The Aldwick Bay Estate

I The Dunes, Aldwick Bay Estate.

Ref AW/I63/I5/HH

“3 Storey extension including moving living area to first floor level & 2 bedrooms with en-suite in the roof.”

NEW EAST ELEVATION

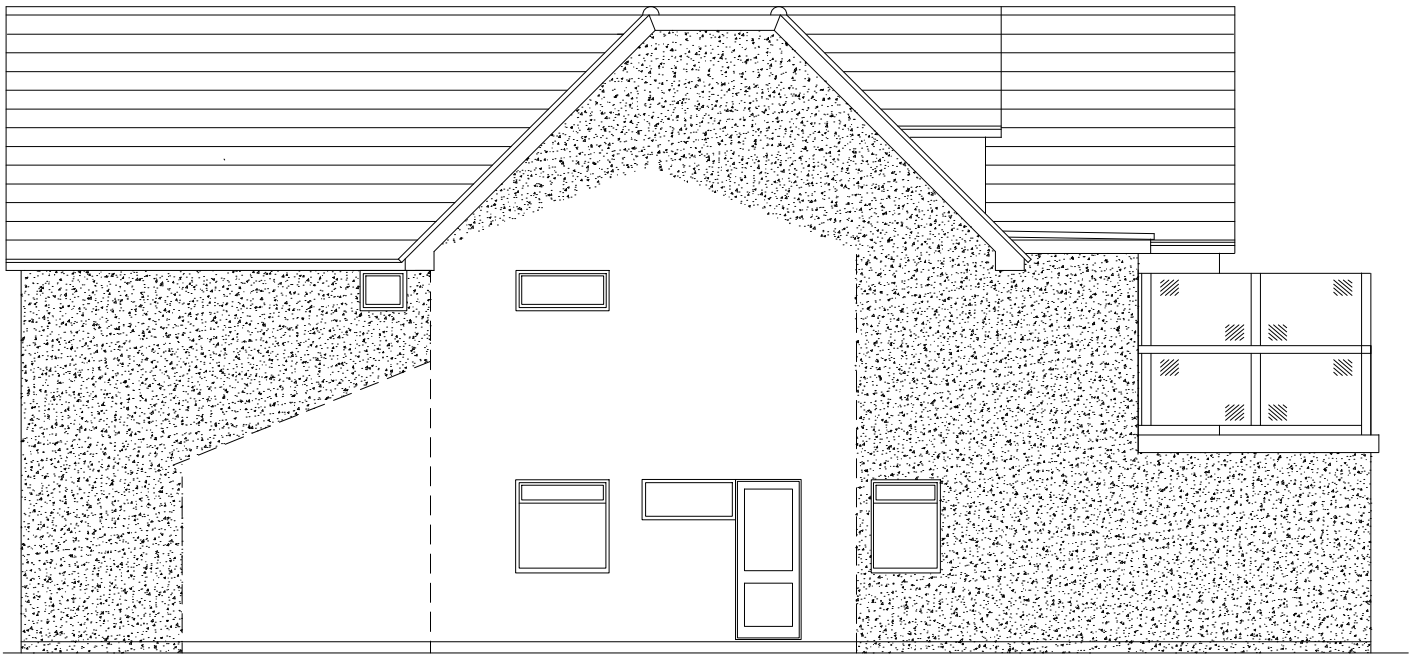
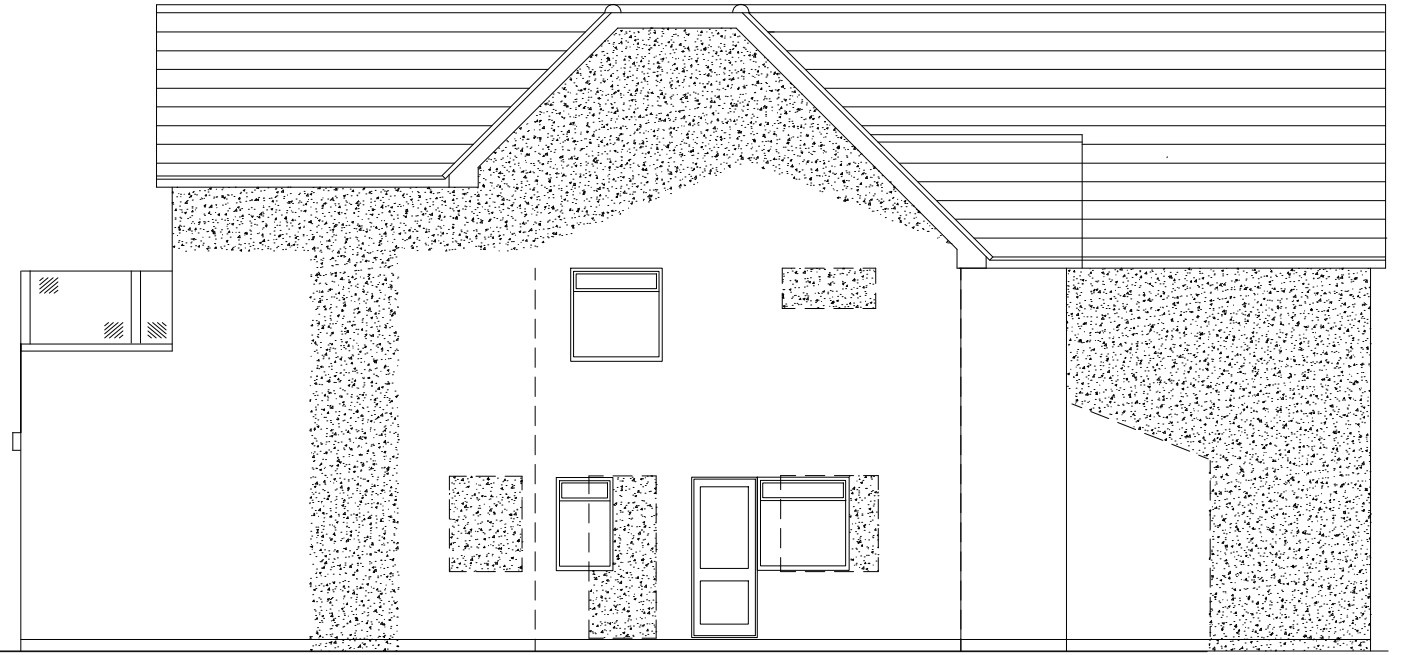
1. The other properties in The Dunes have hipped roofs, thus presenting a 2 storey building with rooms in the roof. The proposed gabled roofs on this application represent a full 3 storey building which is out of character for the street and the adjoining Conservation Area.

2. Gabled roof in addition give rise to more overshadowing.
3. The proposed east and west elevations have not been given any consideration in terms of their appearance. In particular the east elevation which is a street elevation, facing a'Becket's Walk and the Conservation Area deserves to be treated with due consideration in terms of its appearance and not be merely a left over product of the internal accommodation the applicant is looking for.

4. The site plan shows an incorrect footprint of the property to the west and it is therefore not possible to fully appreciate the impact the proposals will have on the adjoining property. The proposed heights however, very close to the boundaries will give rise to serious overshadowing and impact on the amenities of the adjoining property.

5. There are overlooking issues with some of the propose windows and balconies.
